# Drainage Letter Report

1830 MAIN STREET  
COLORADO SPRINGS, COLORADO  
80911

December 2, 2019

PPR1938

Appendix G: Sub-Basin Delineation Exhibits

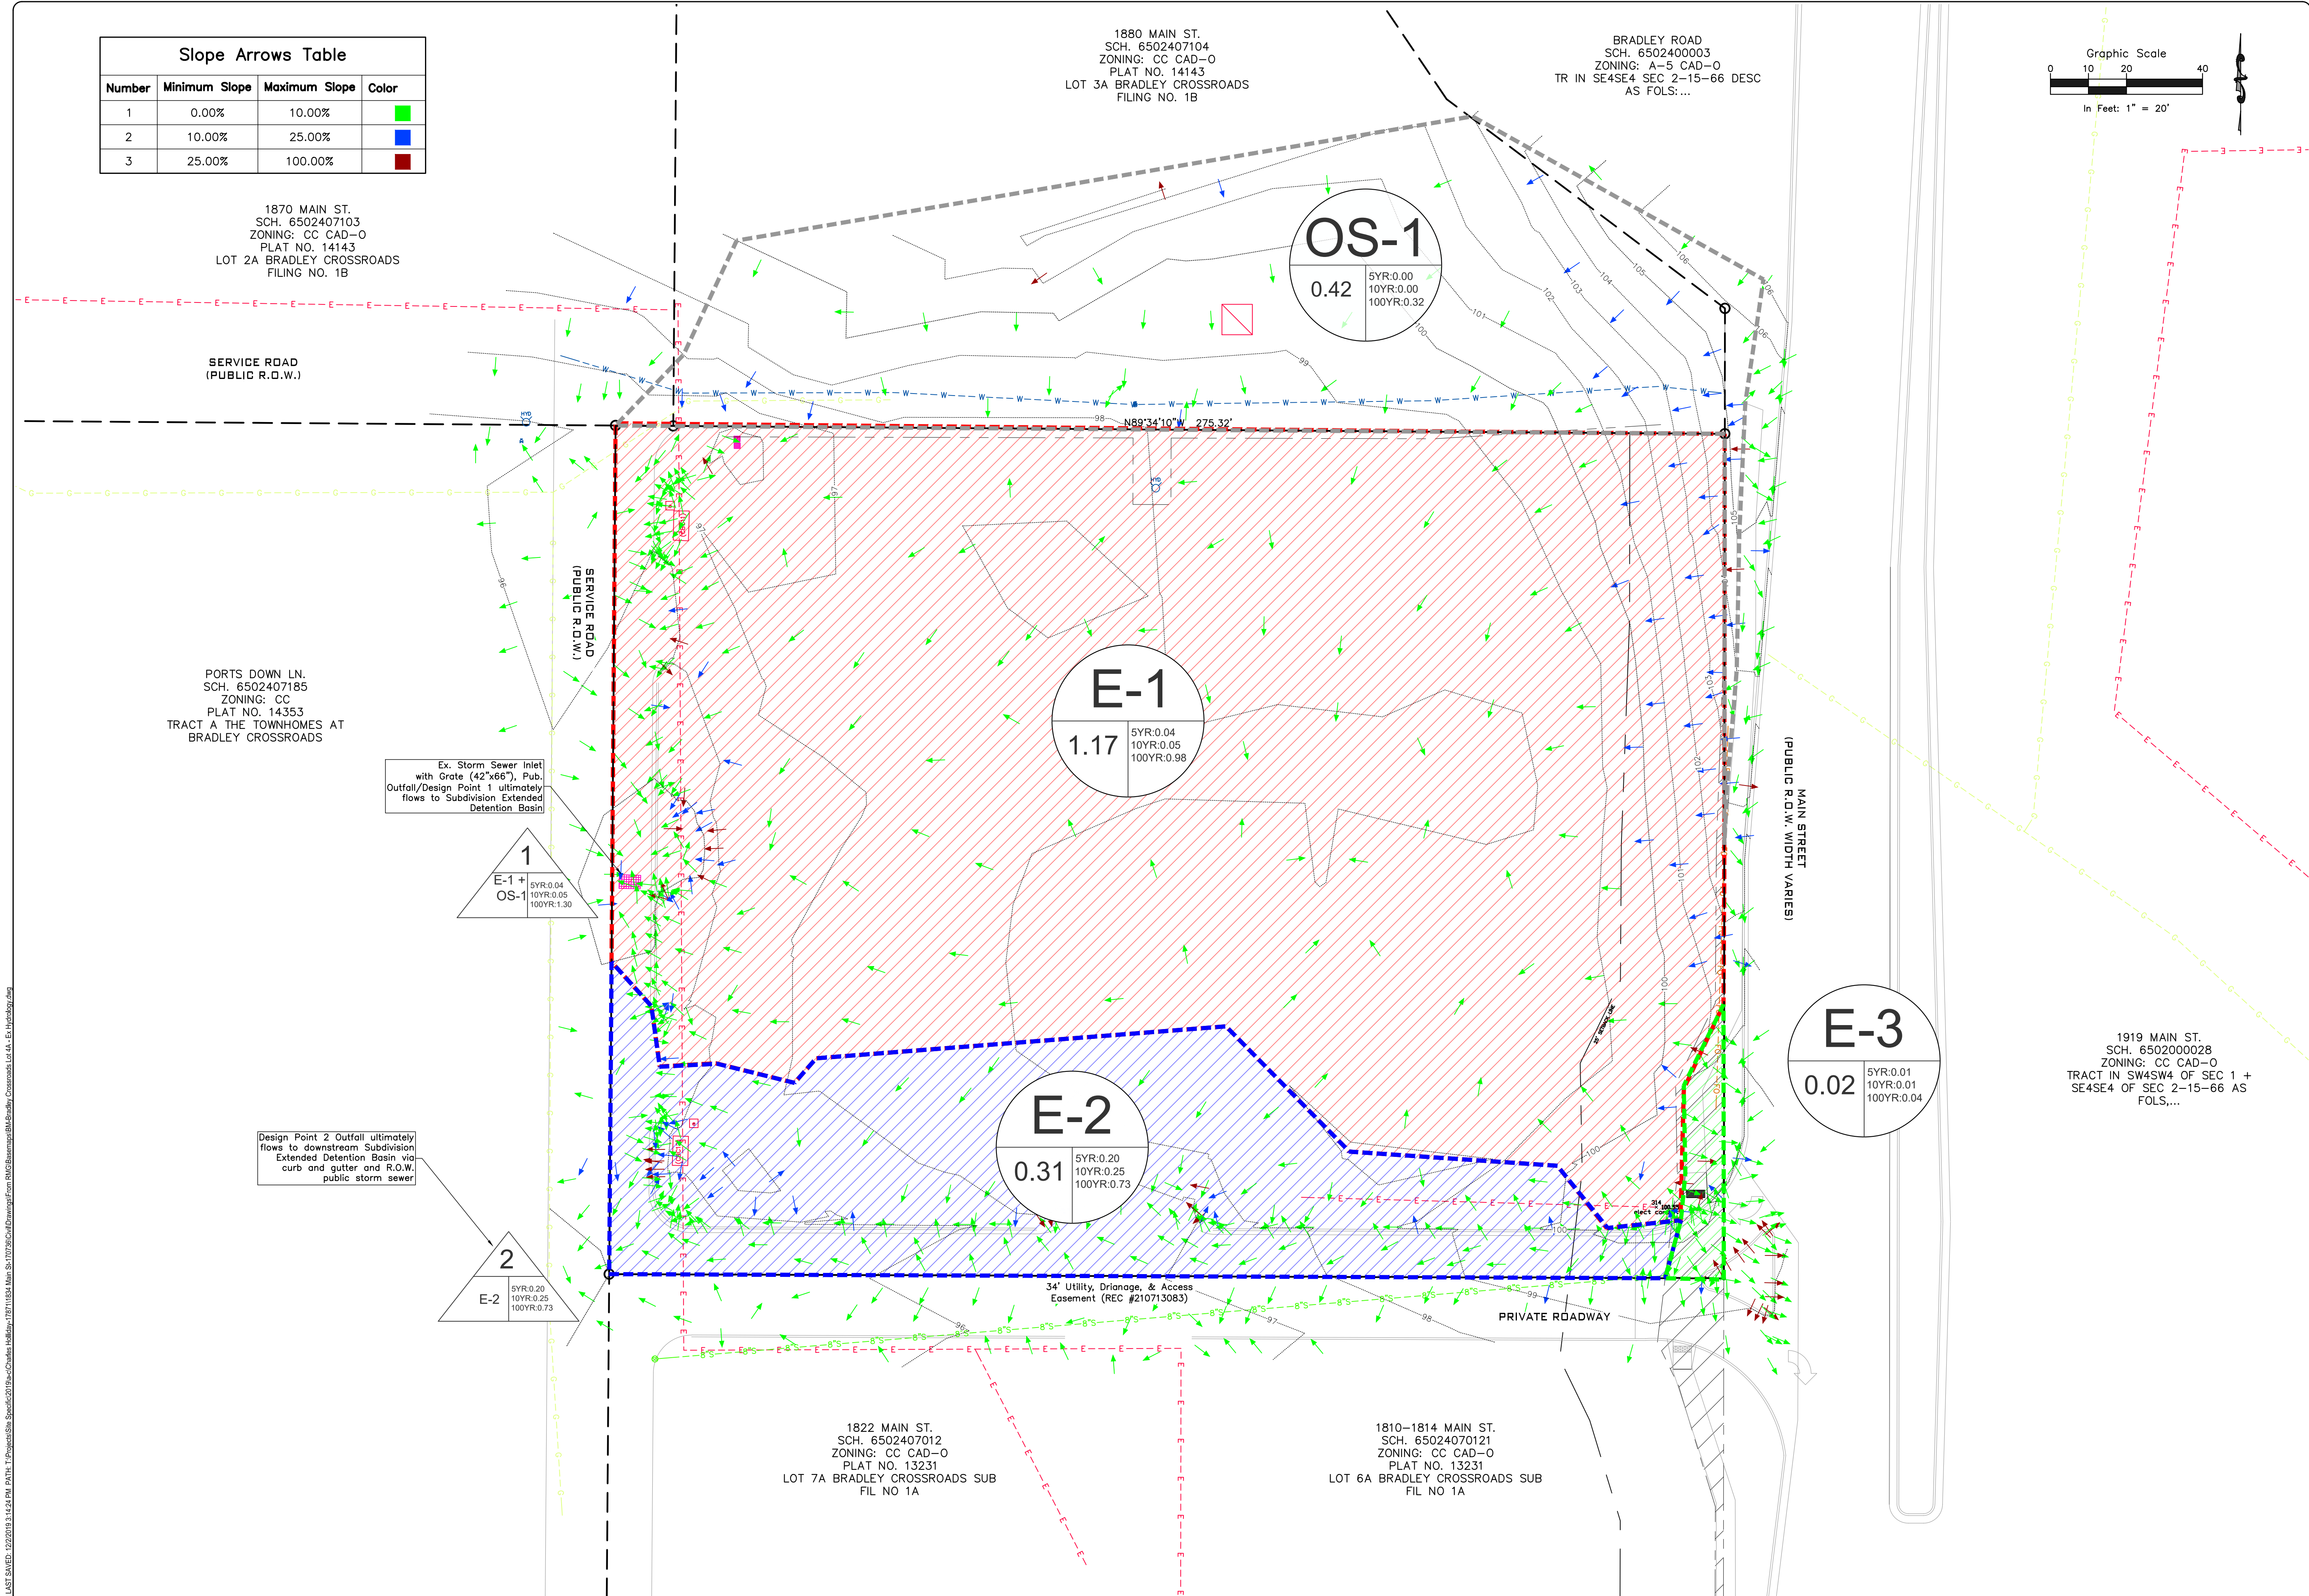
which is it? is it split? my map shows that it is in the little Johnson. Please clarify which of these basins or if it is split between the two? or redirected from one to the other? see your text on next page that describes this site accurately.

DETAIL A - EXISTING EXTENDED DETENTION BASIN FOR LINCOLN COMMONS TOWNHOMES
N.T.S.

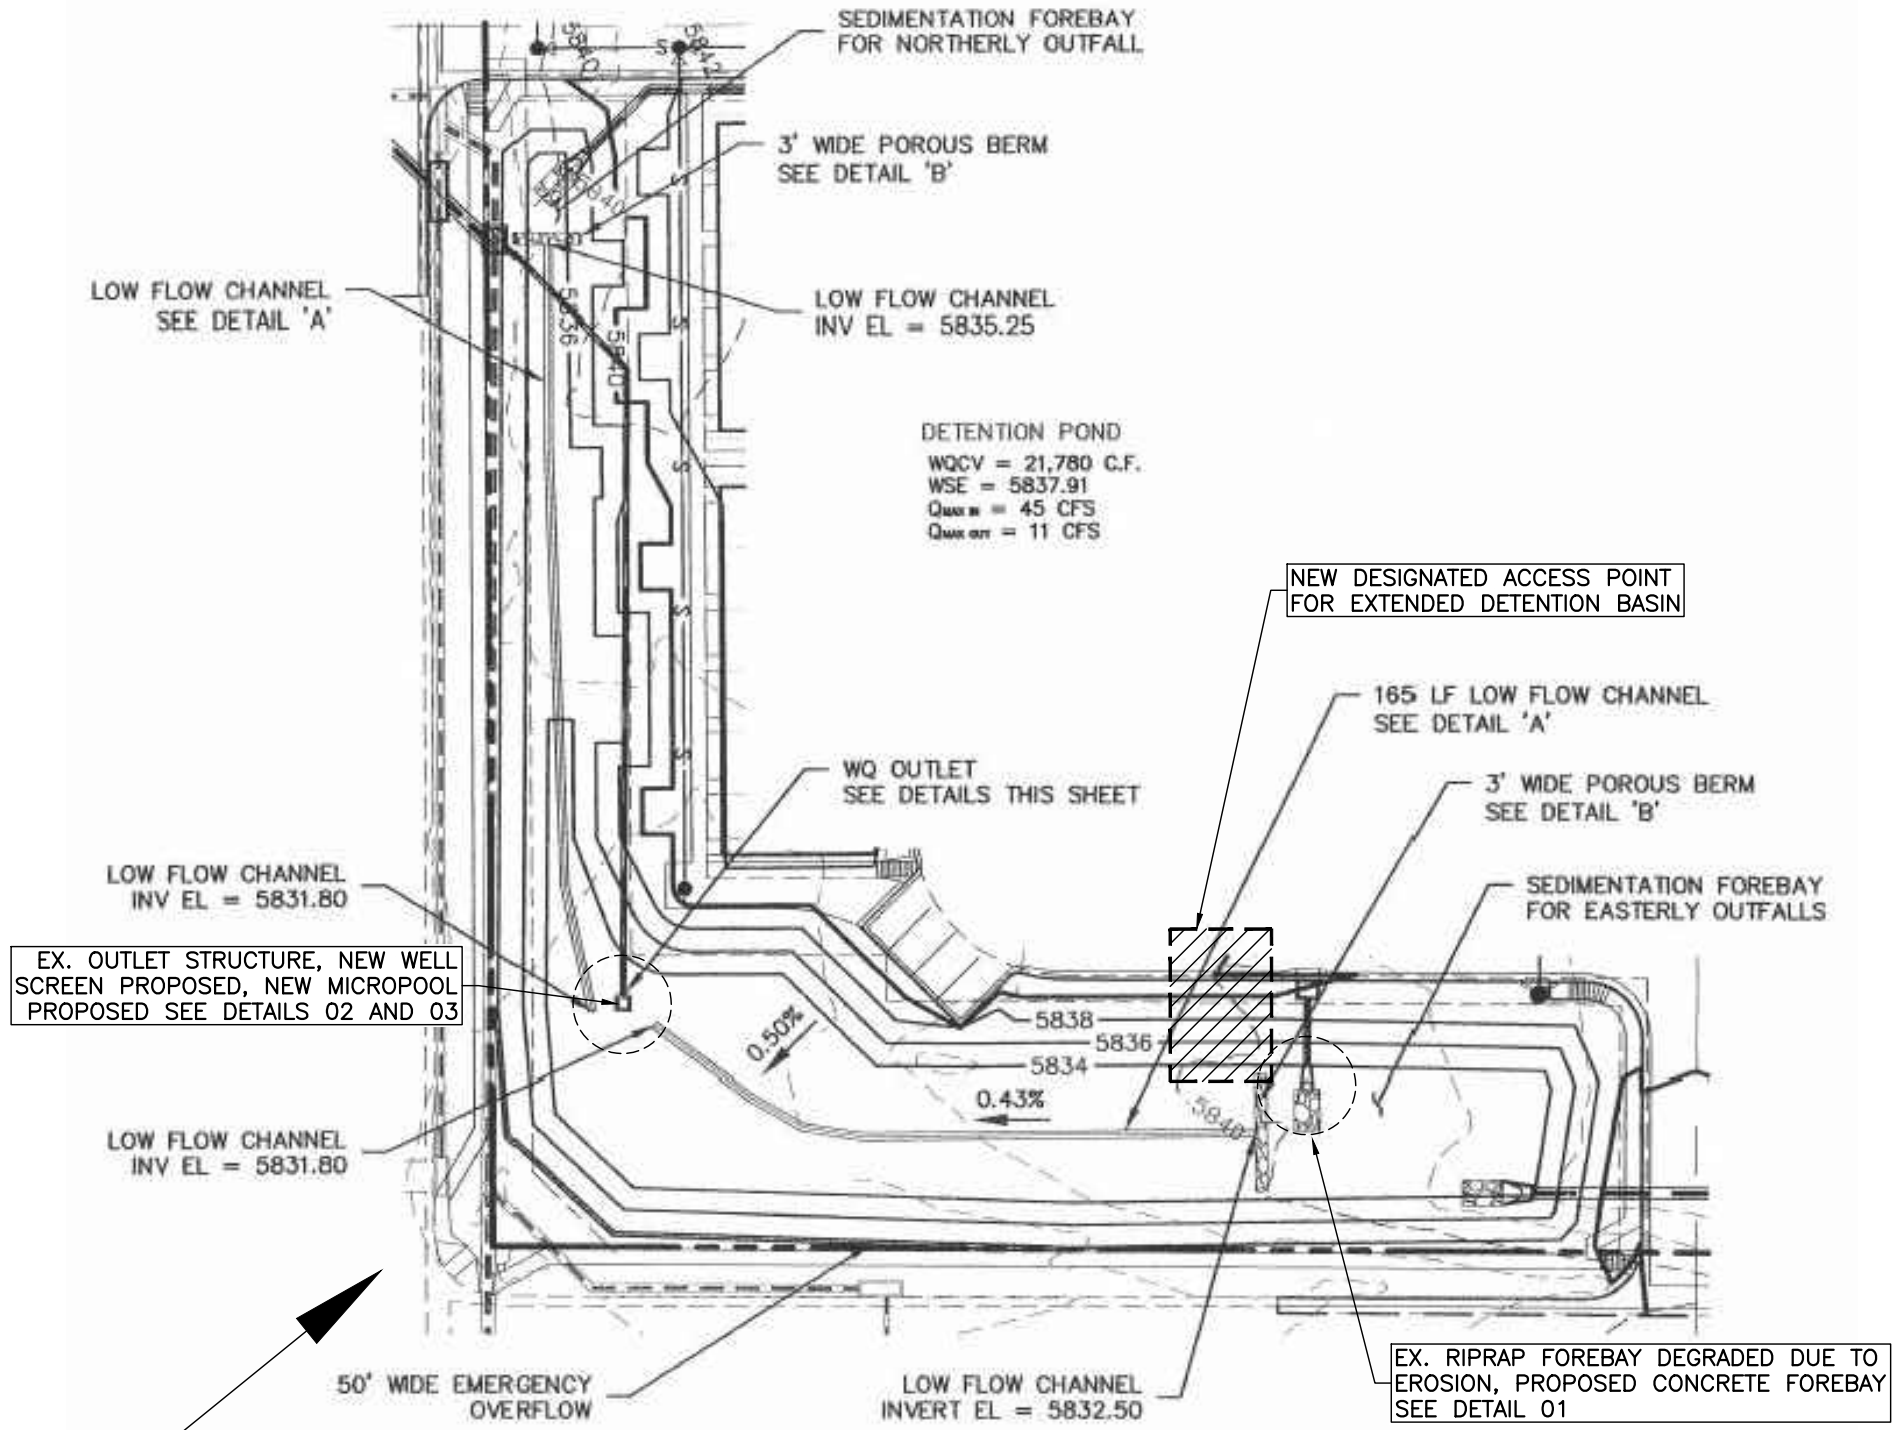
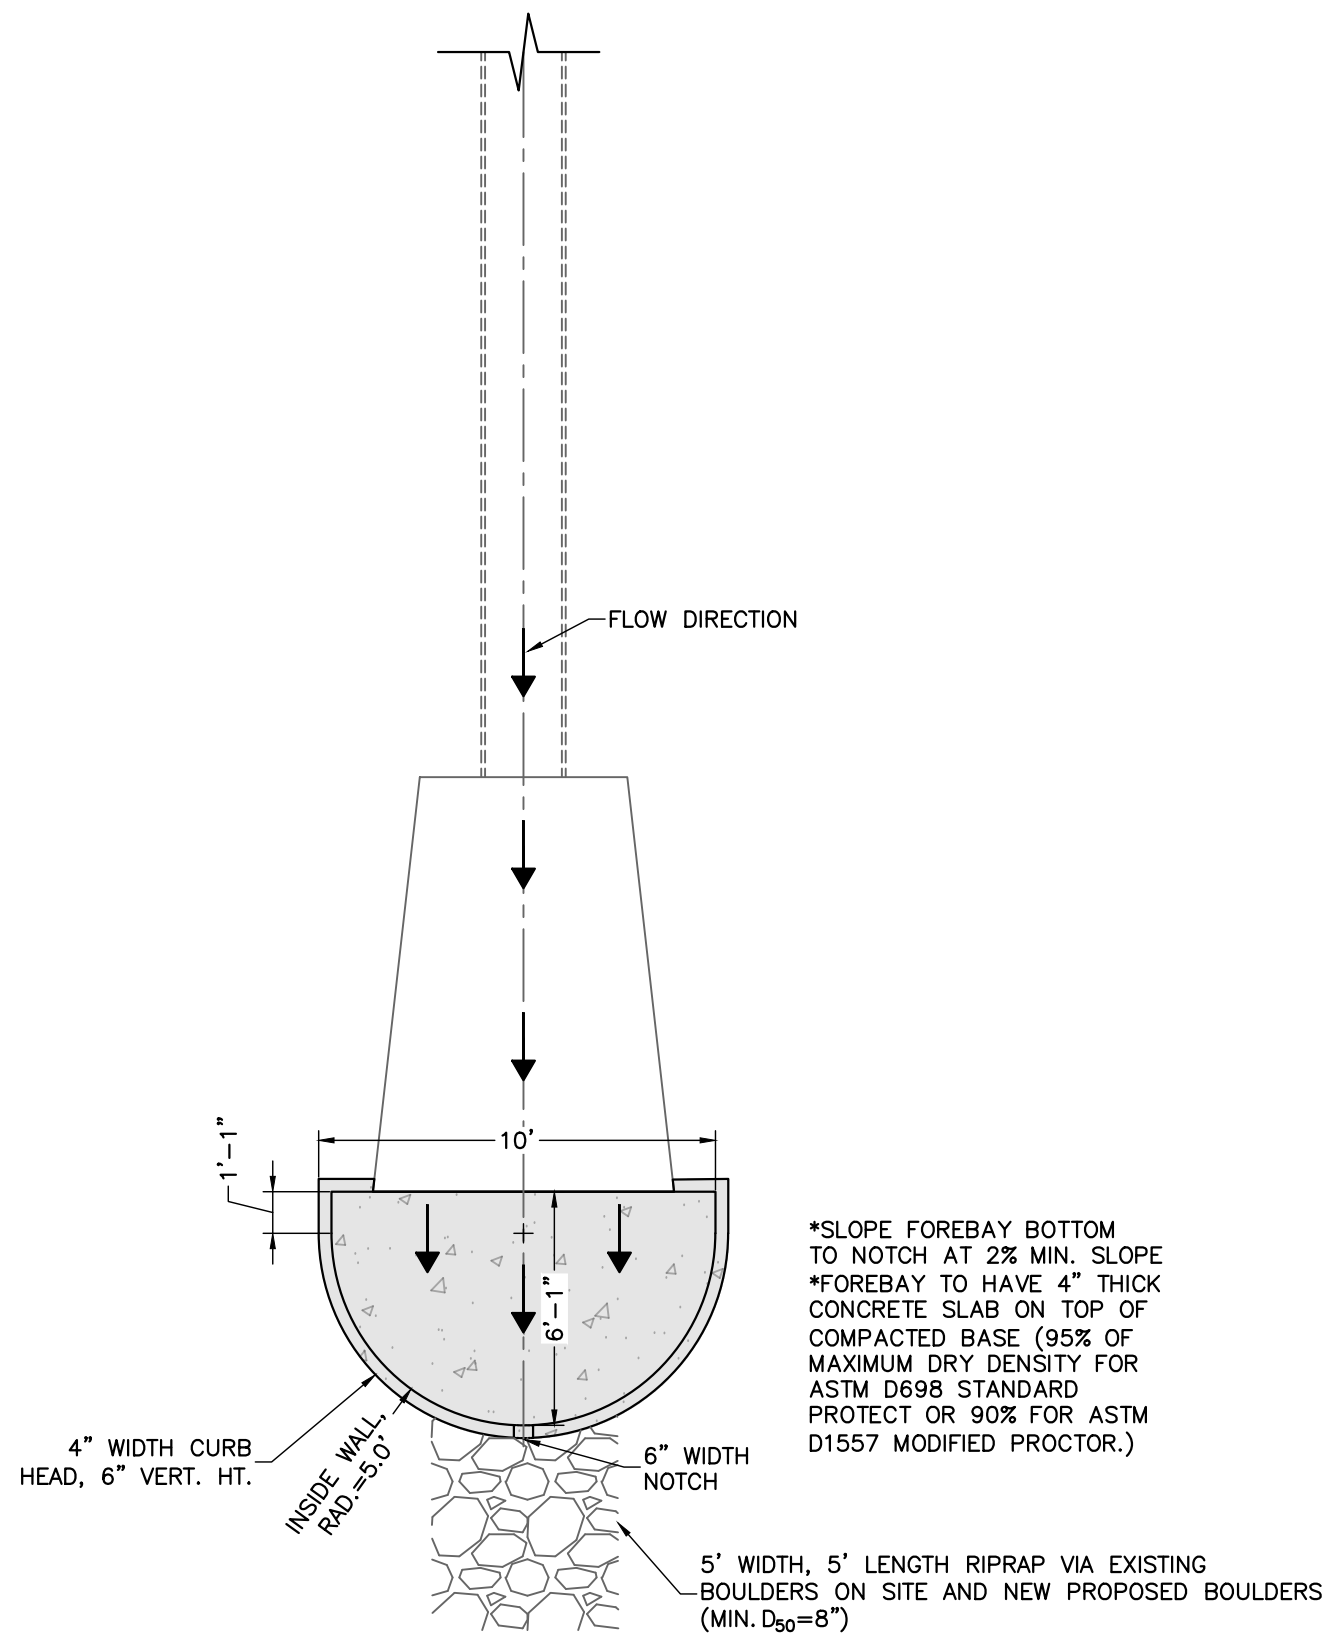
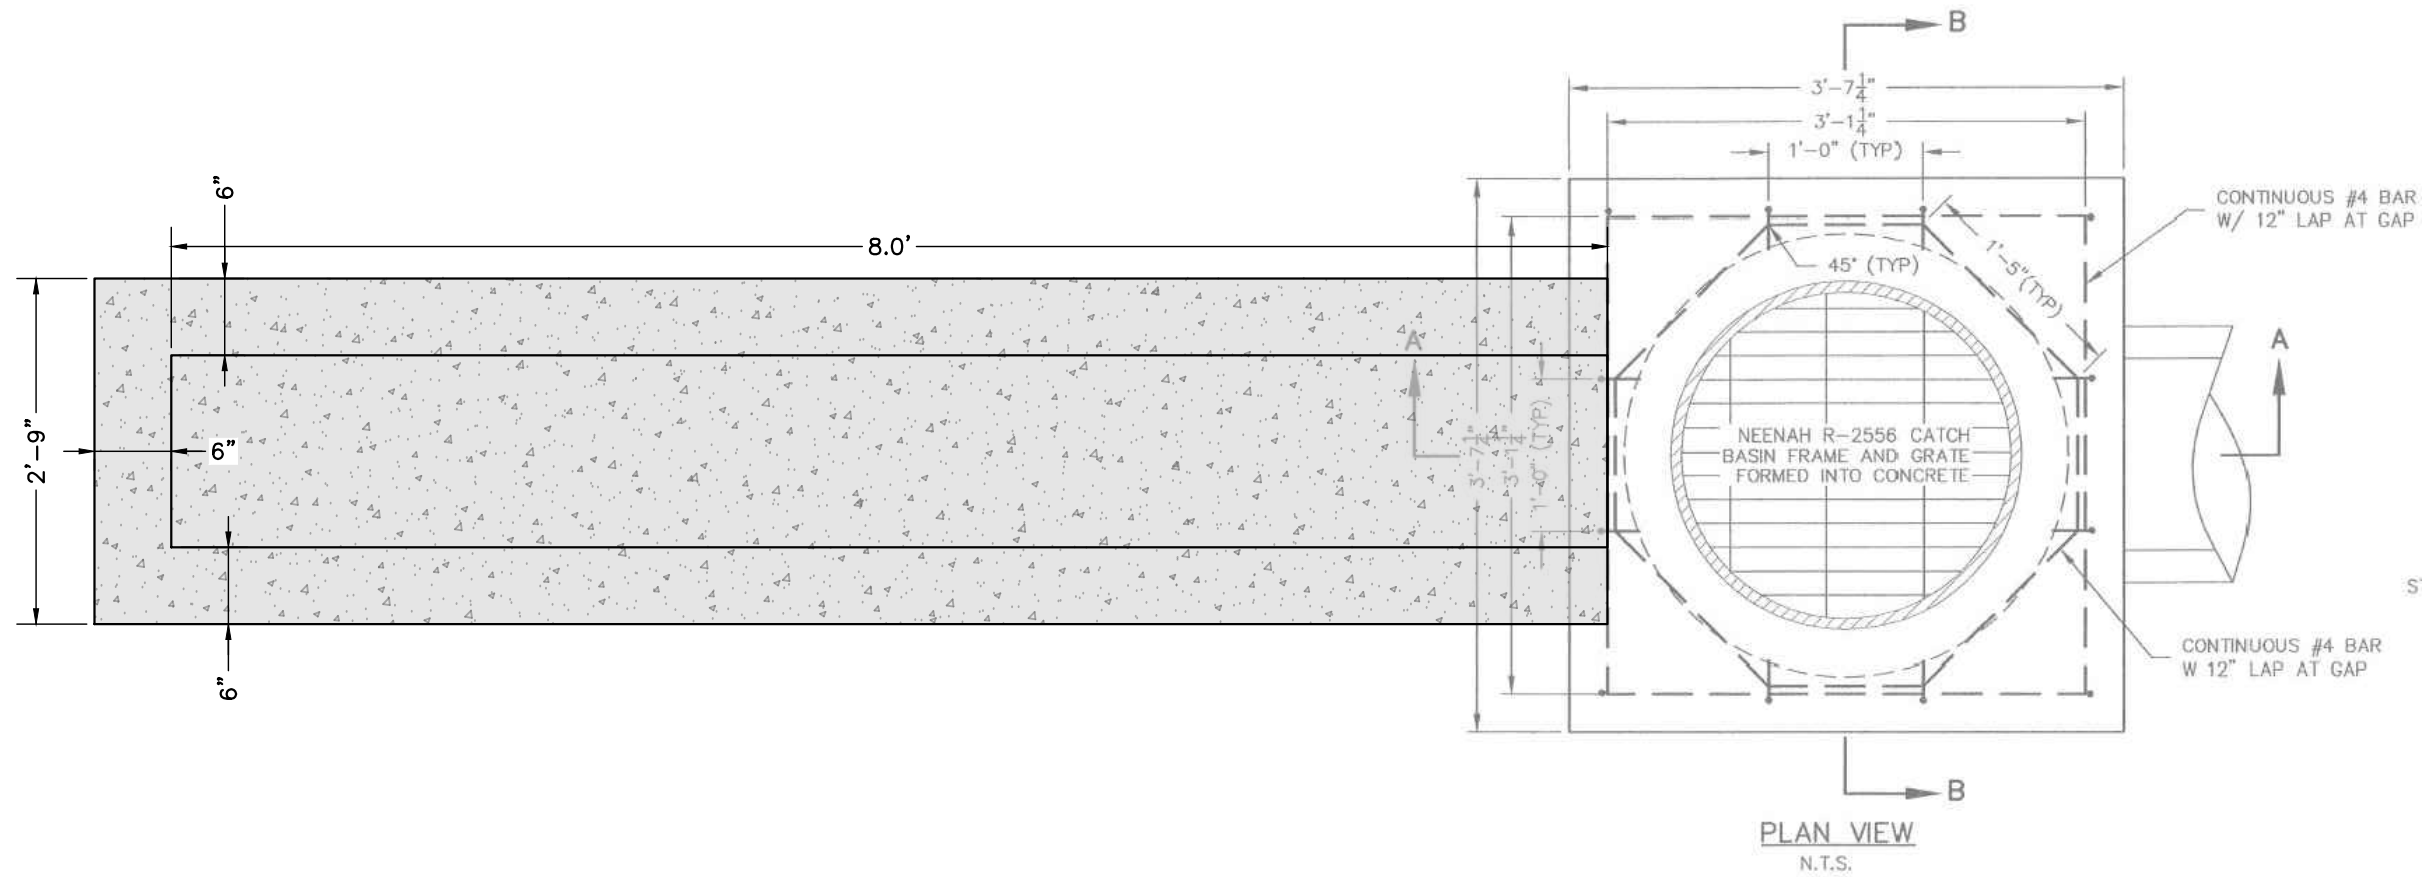
Calculate the SWQCV and FSD volume for this site and show how these volumes are accounted for in the downstream detention facility. Does the downstream facility meet current criteria for SWQCV? does this facility provide the detention required by previous reports and the DBPS?

confirm/state that the existing pond is within today's criteria as well confirm that other lots which drain into the pond have not eaten into the SWQCV and the FSD volume for the existing pond. Or confirm with an overall calculation of existing condition (with allowances for any lots not developed at this time) reference EPC file # SF 07012 in your report and start there please. State that the current pond is functioning as designed or state what work this site should do to get into working order.

Rich, confirm that you are in compliance with the original reports impervious ratio and leave it at that. use the SF07012 report to see what your site was designed for. Please still state that the current pond is functioning as designed or state what work this site should do to get into working order (ie clean outlet structure, i do not know this, i am sending someone out to check??). You will also need to state what size the pipe is that transports your flow to the pond, and state that it is adequate. I believe it was designed and installed with the Townhomes at Bradley, VR104 project.
